CITY OF PORTLAND BUILDING PERMIT

PERMIT ID: 2012-65593

RE: Building Permit Application – Portland Community Health Clinic Renovations,
180 Park Avenue, Portland, Maine

Portland Community
Health Clinic- Renovation
Project

PHASE 1 EXITING PLAN

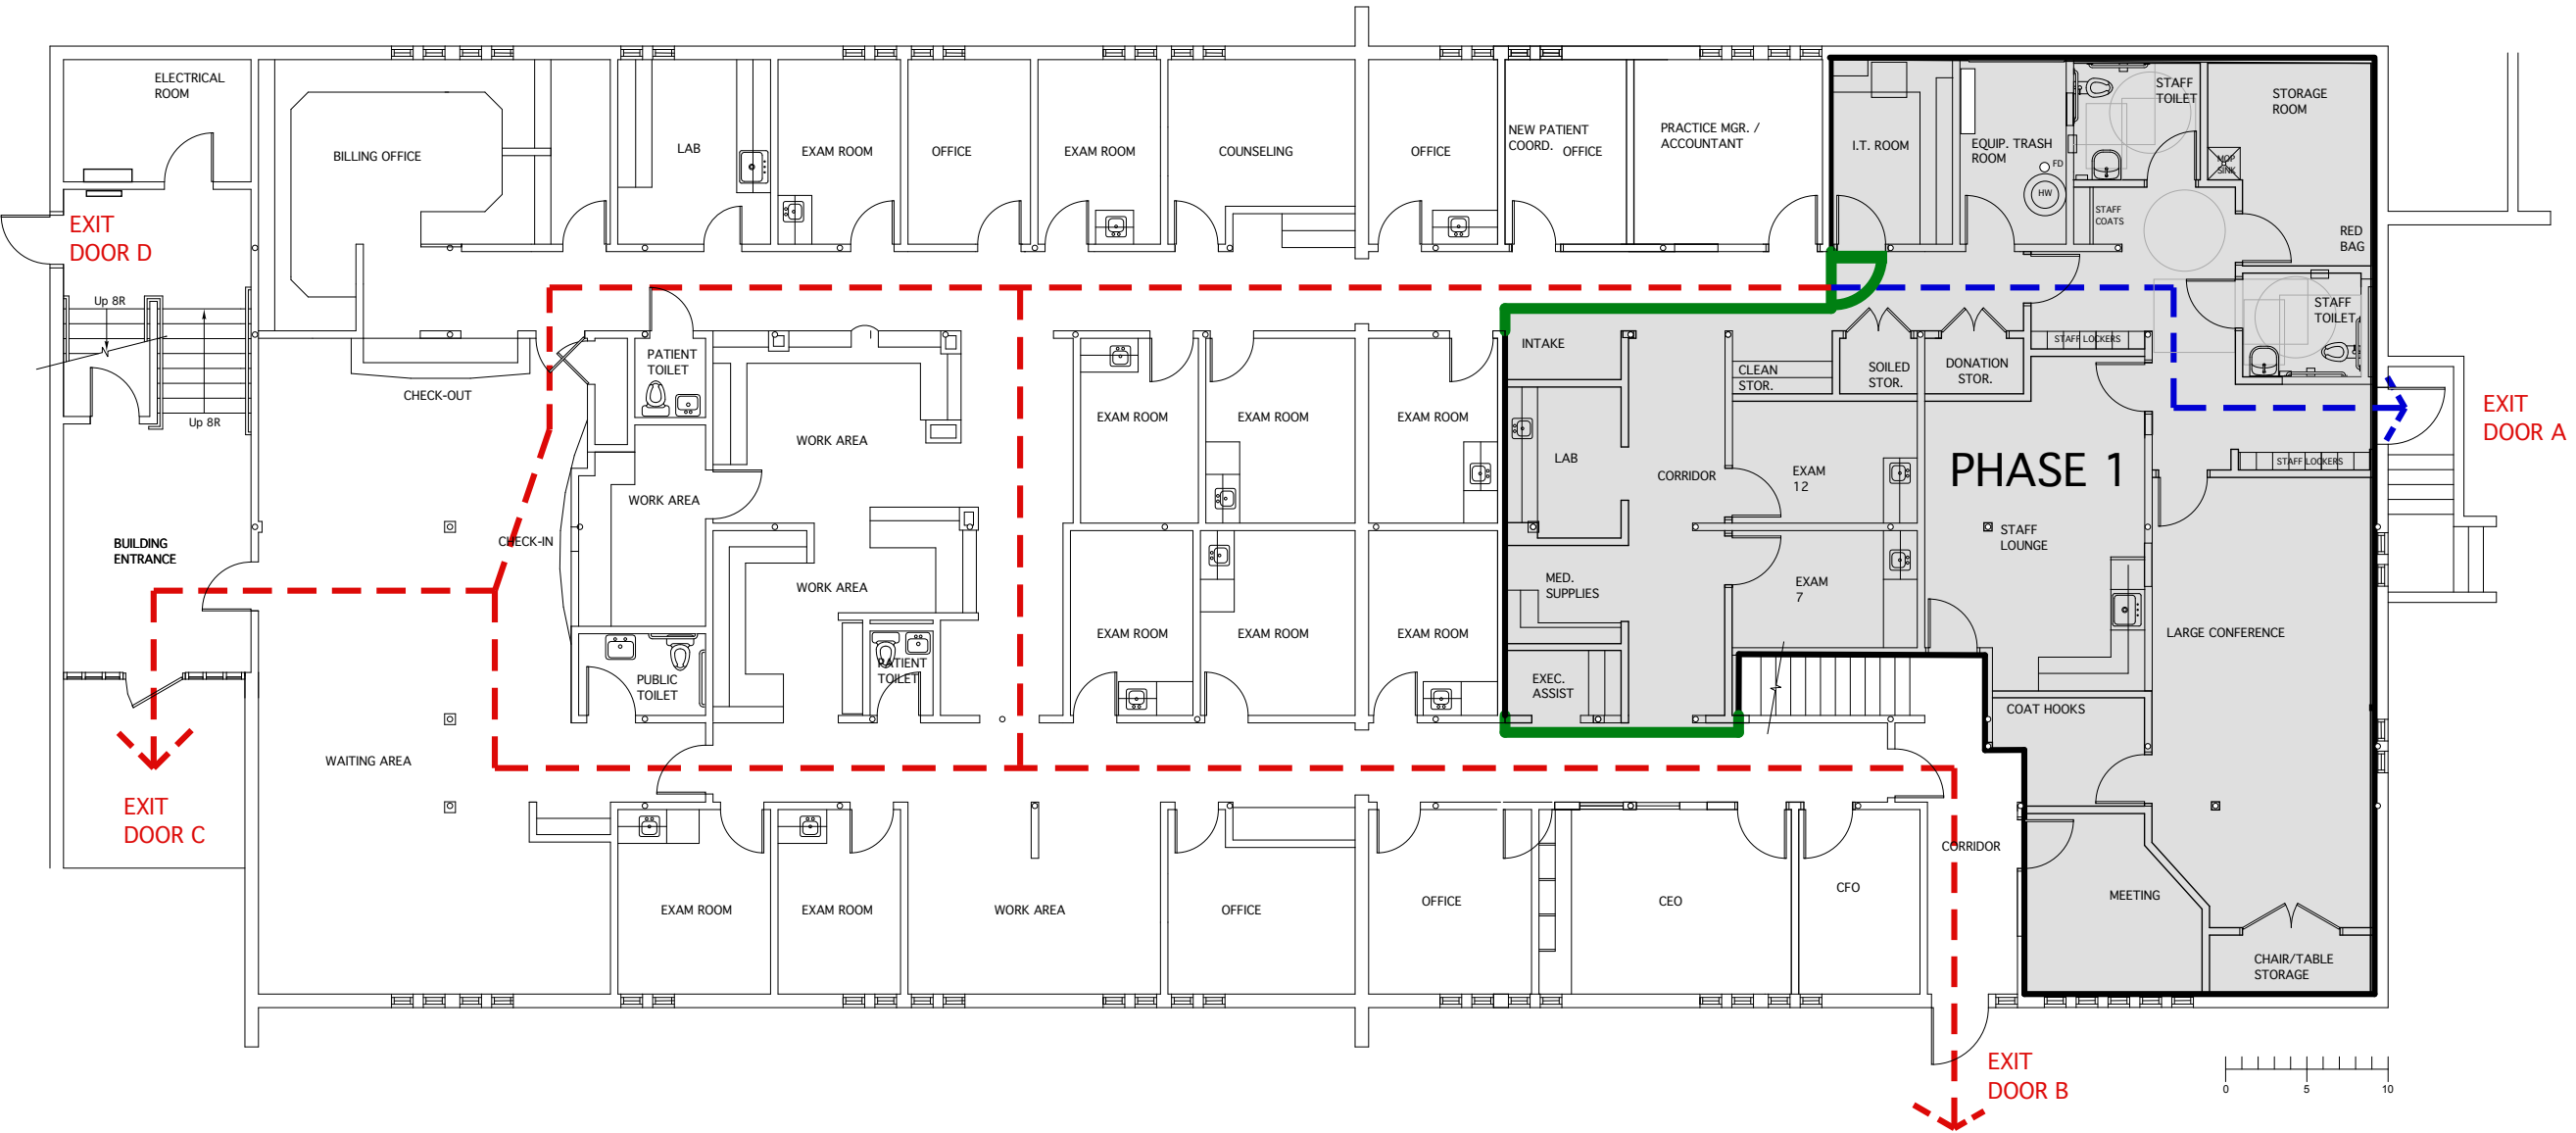
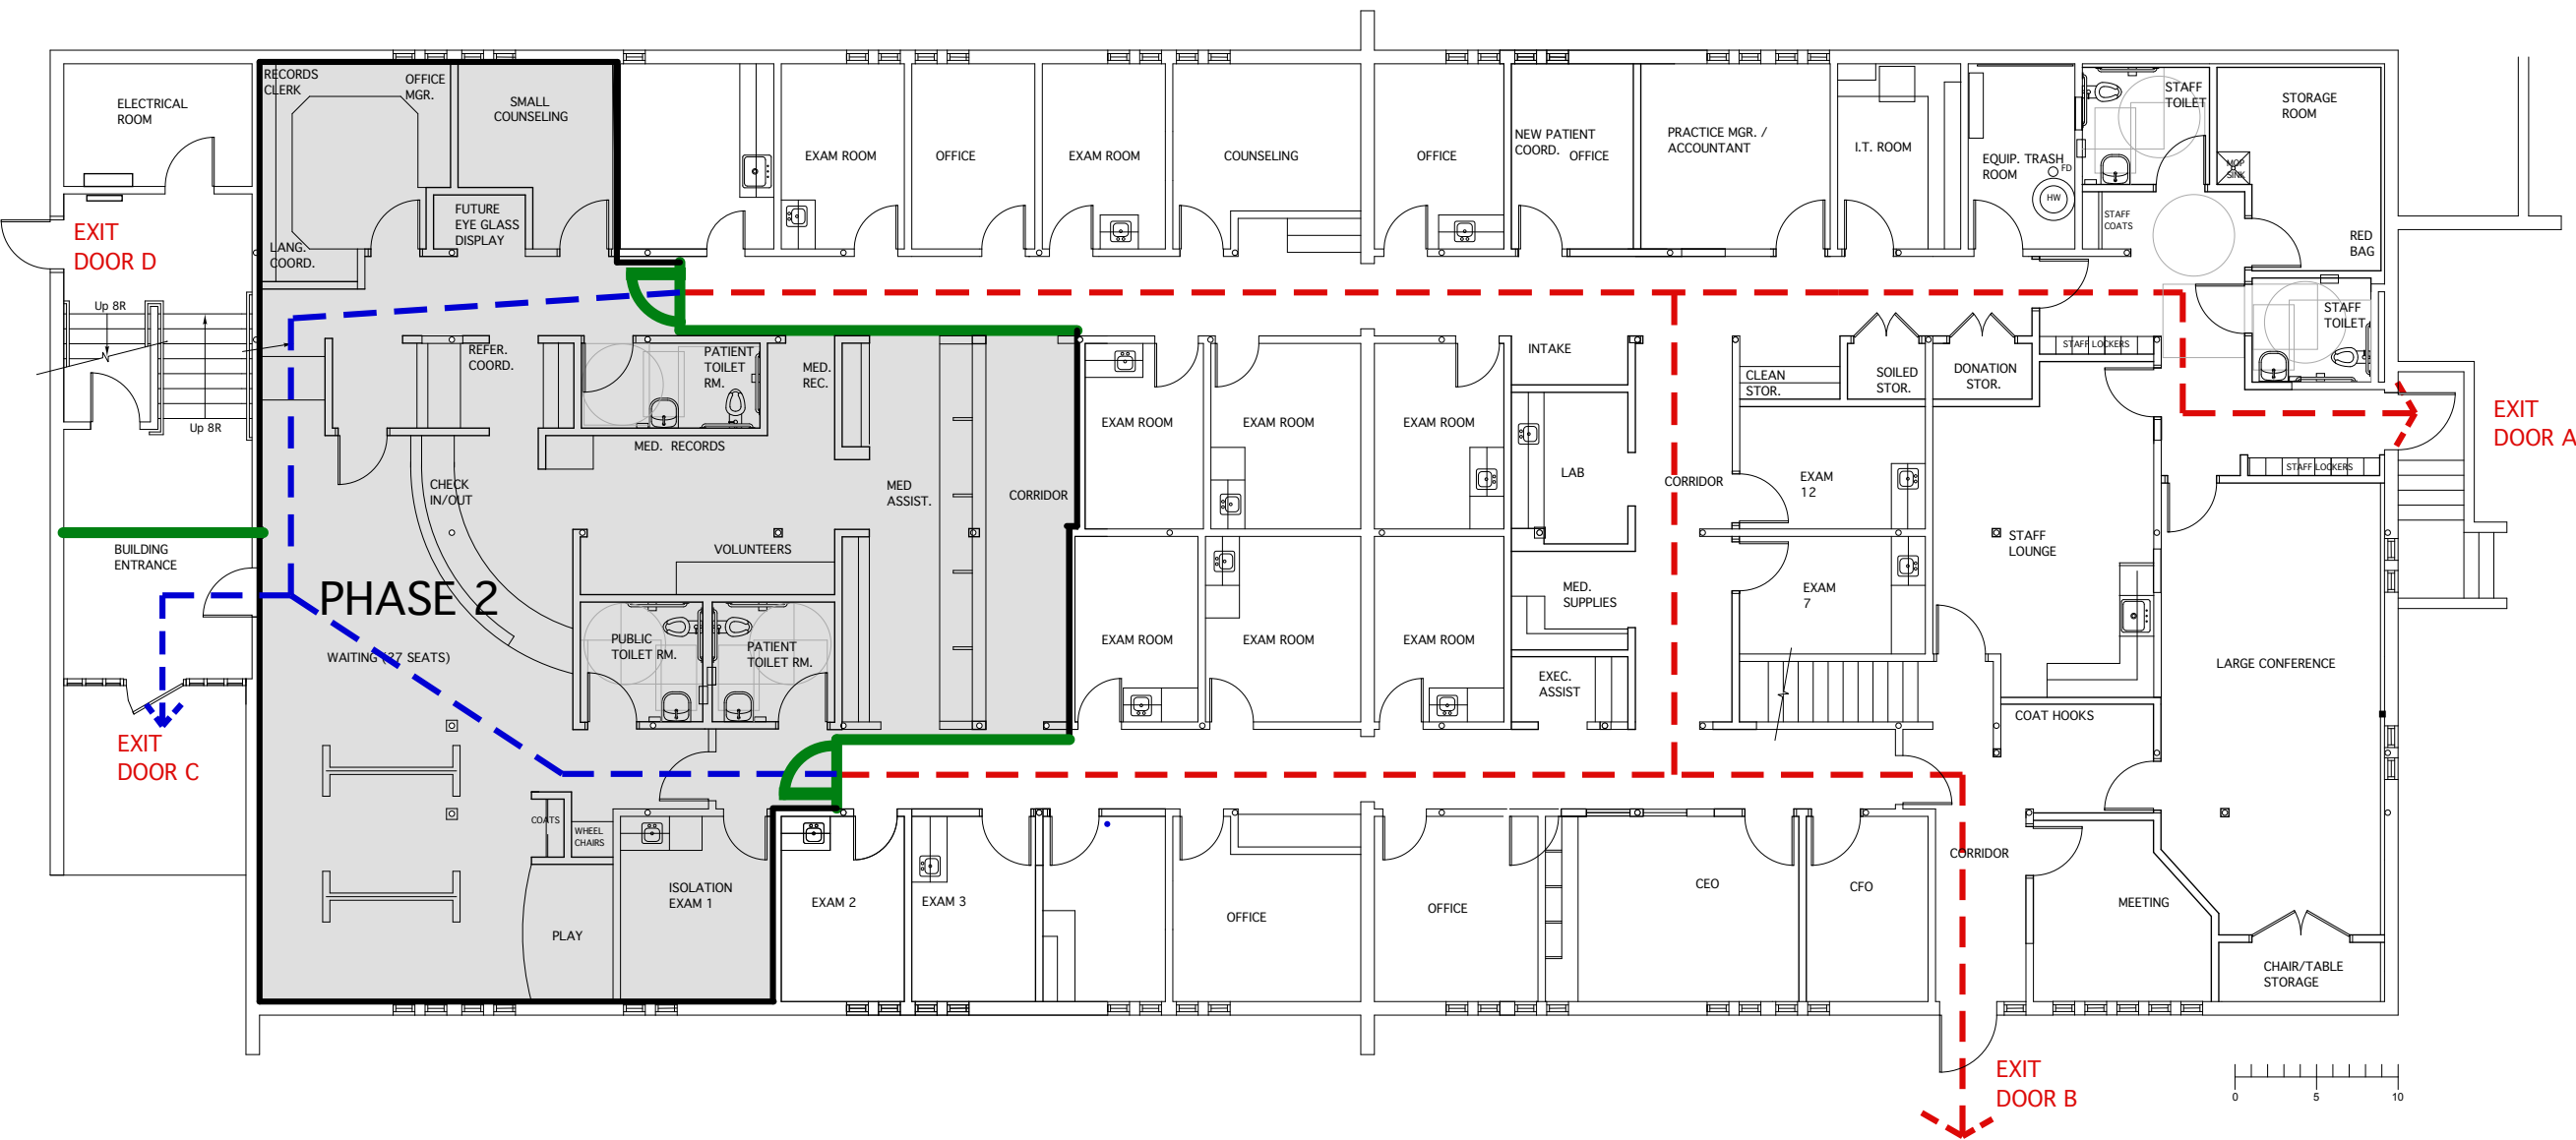
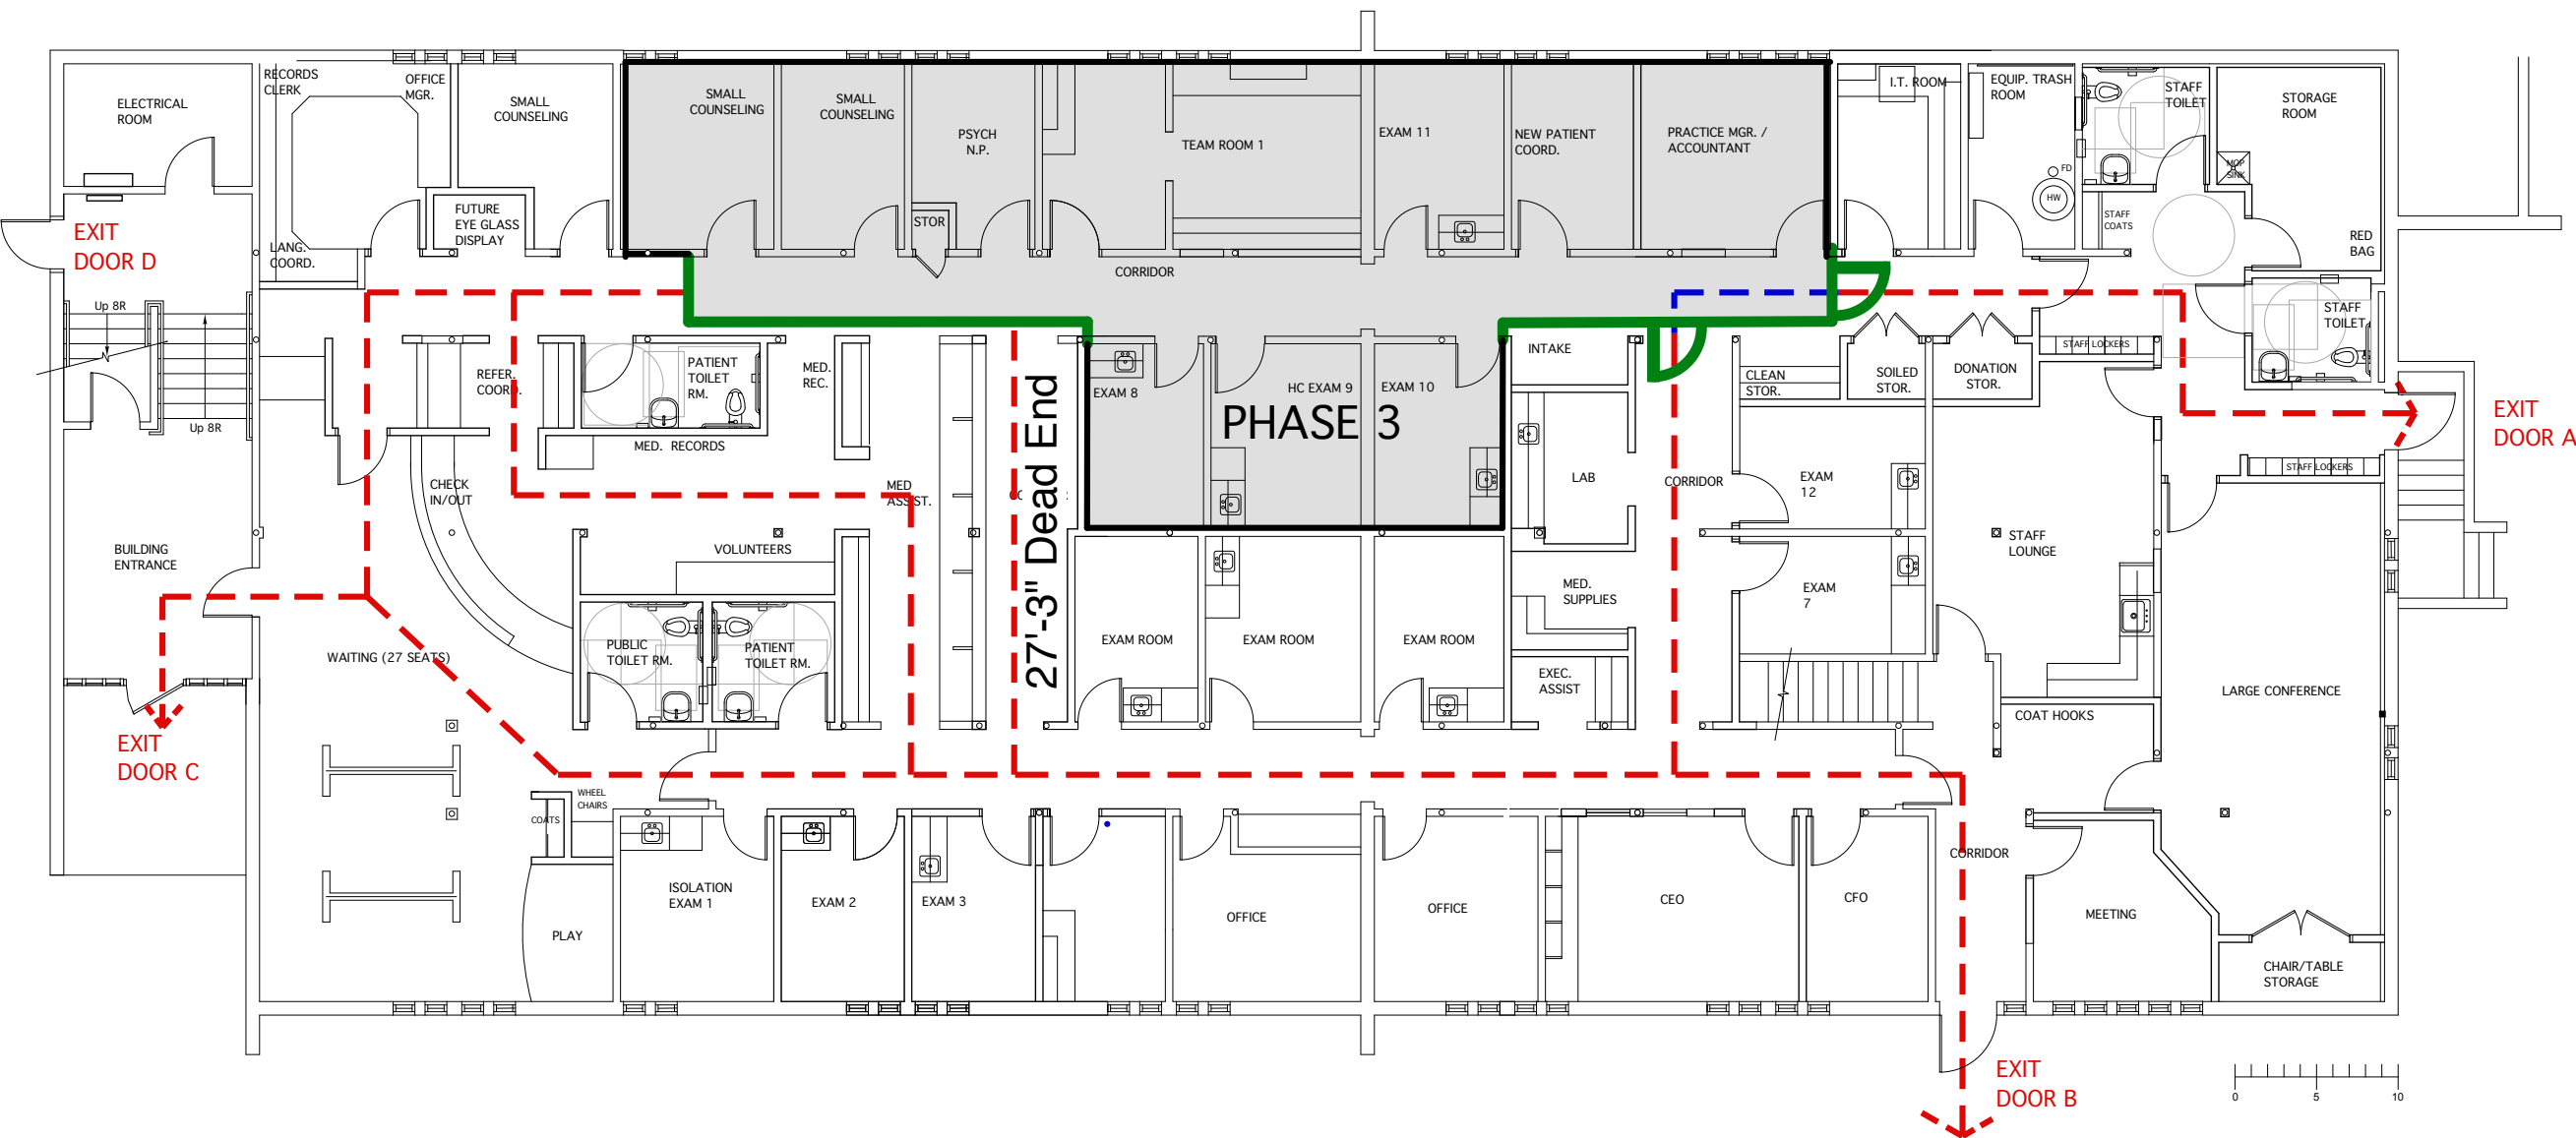
As discussed I have put together a series of phasing/exiting plans that show proposed exit paths during construction. The excessive dead end corridors you noted in your review can only be avoided by adding doors (signed as emergency exits) in the temporary partitions that would allow exit paths to traverse the construction areas.

While having people have to exit through the construction areas is not ideal, I have tried to locate the paths in areas of low impact construction. Our plan would be to instruct the contractor that he needs to keep the exit paths clear and signed so that the path to the exit door is clear and understandable to building occupants. We will also review interim exiting plans with the staff so everyone is made aware of the adjusted paths to exits at each phase.

These through construction alternate route egresses are acceptable per IBC Sec. 3302, considering the phasing schedule and desired occupancy of the space. As you have summarized, clarity in these areas should be of high priority, closely monitored, and instructed to the occupants.
